Your ref: SSD-73761707
File no: MC-25-00004

SSD-73761707 - Notification of exhibition of a State Significant Development Application for Glendenning Road Data Centre

Blacktown City Council's submissions to SSD-73761707

Figure 5. Site Catchment and Overland Flow Path Plan

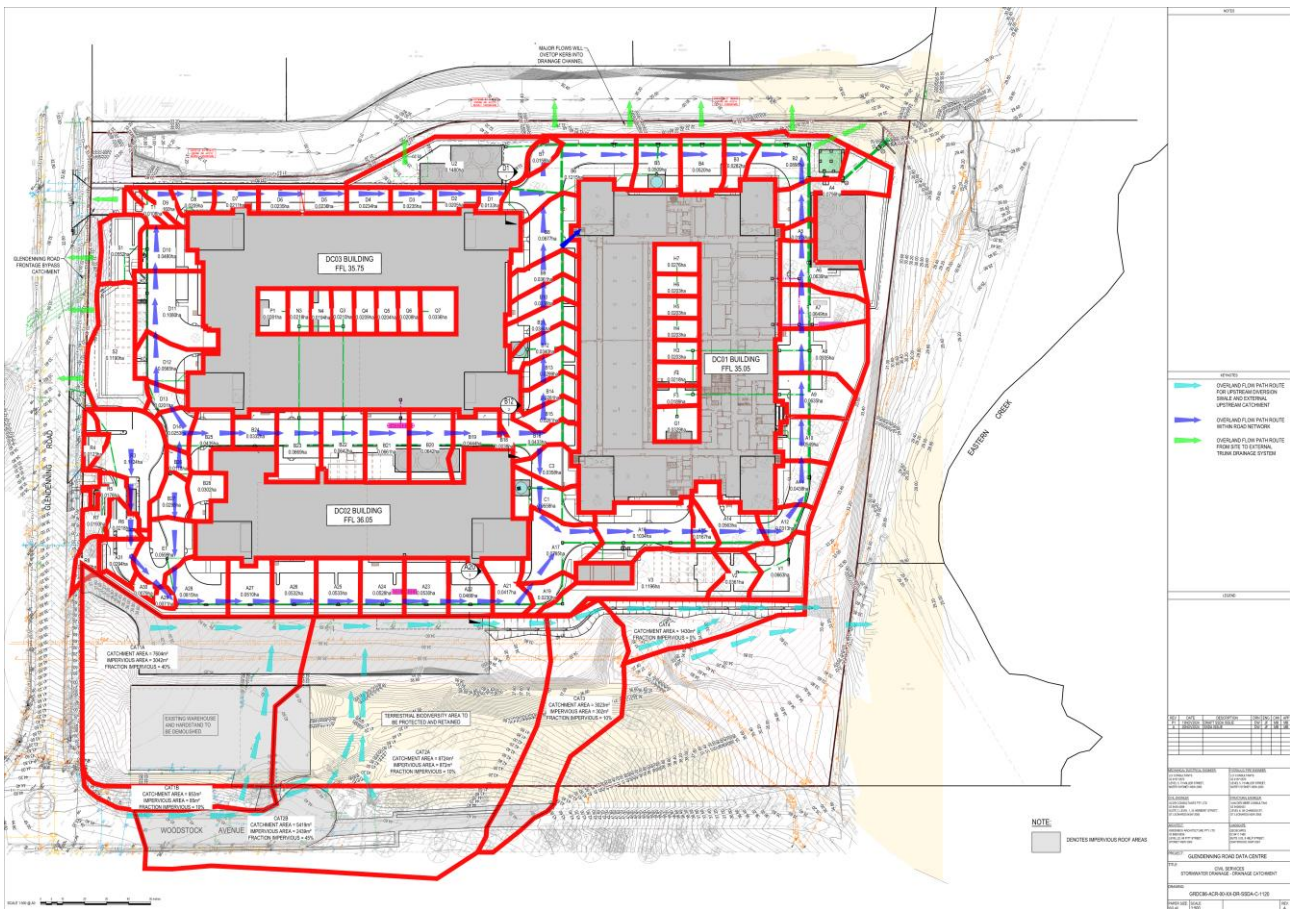
- j. A water quality catchment plan must be provided.
- k. With regards to flooding, the site is affected by an overland flow in both low and medium risk. The development proposed significant cut and fill within the site. The existing overland flow path will be disturbed and it may lead to negative flood impacts to the roadway and surrounding properties. The amended flood risk report must verify the changes. Alternatively, a flood modelling may be required to determine the impact of the development.

Figure 6. North-East Stormwater Outlet Position

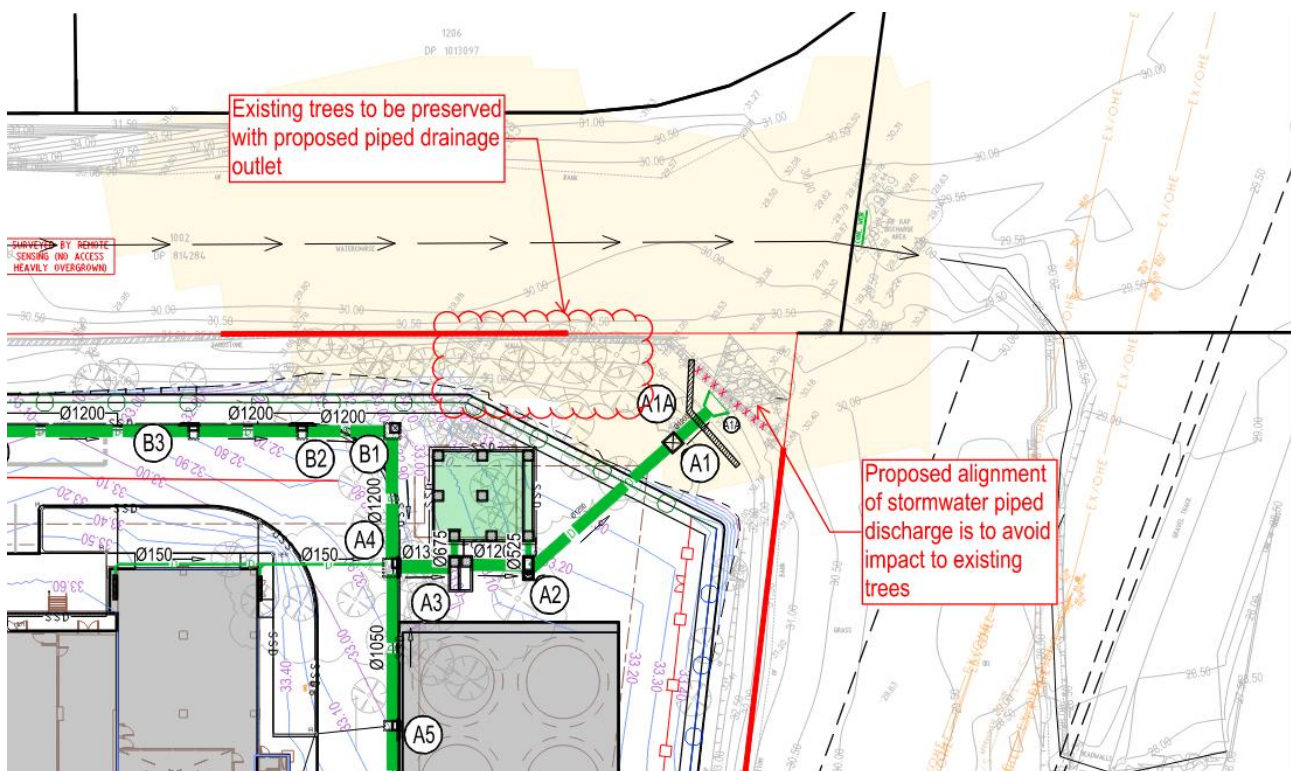
- h. Please provide the details of proposed headwalls with scour protection in accordance with Council standard drawing
- i. Please provide the SEI calculation when no OSD is required in the lot.
